Fire Marshal Division

**Re: Coats Outdoor Adventures
30 S. McKinley St.
Coats, NC 27521**

Application Number BCOM2003-0001

30 S. McKinley Street, Coats

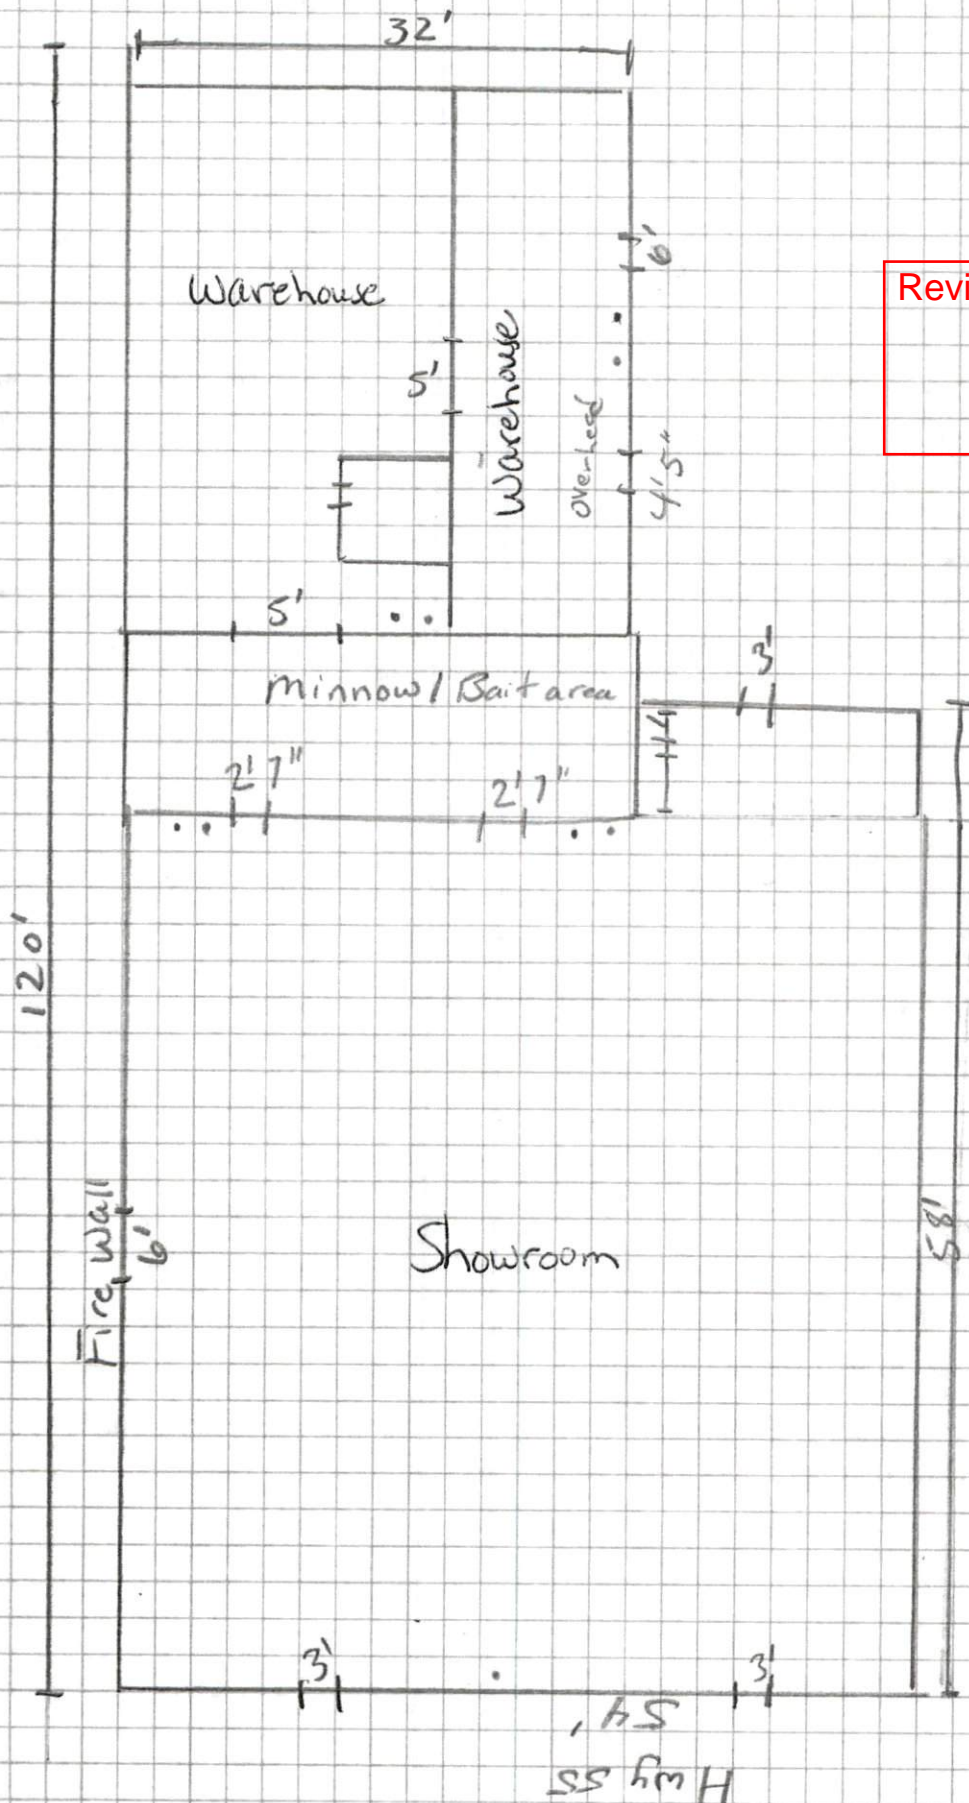
- **Fire Extinguishers**
 - Minimum of (1) 2A10:BC fire extinguisher shall be installed per 75' distance of travel.
 - All Fire extinguisher shall be properly mounted and tagged by a fire extinguisher company.

- **Means of Egress Illumination**
 - The means of egress, including the exit discharge, shall be illuminated at all time the building space is served by the means of egress is occupied.
 - Means of egress consist of three separate and distinct parts: the exit access, the exit and the exit discharge.
 - The means of egress illumination shall not be less than 1 foot-candle at the walking surface.

- **Rated Wall Identification**
 - Rated walls shall be permanently identified with signs or stenciling.
 - **Example: "1 Hour Fire Barrier Protect All Openings"**
 - Rated wall opens and protectives shall be maintained at a rating no less than the rating of the rated wall.
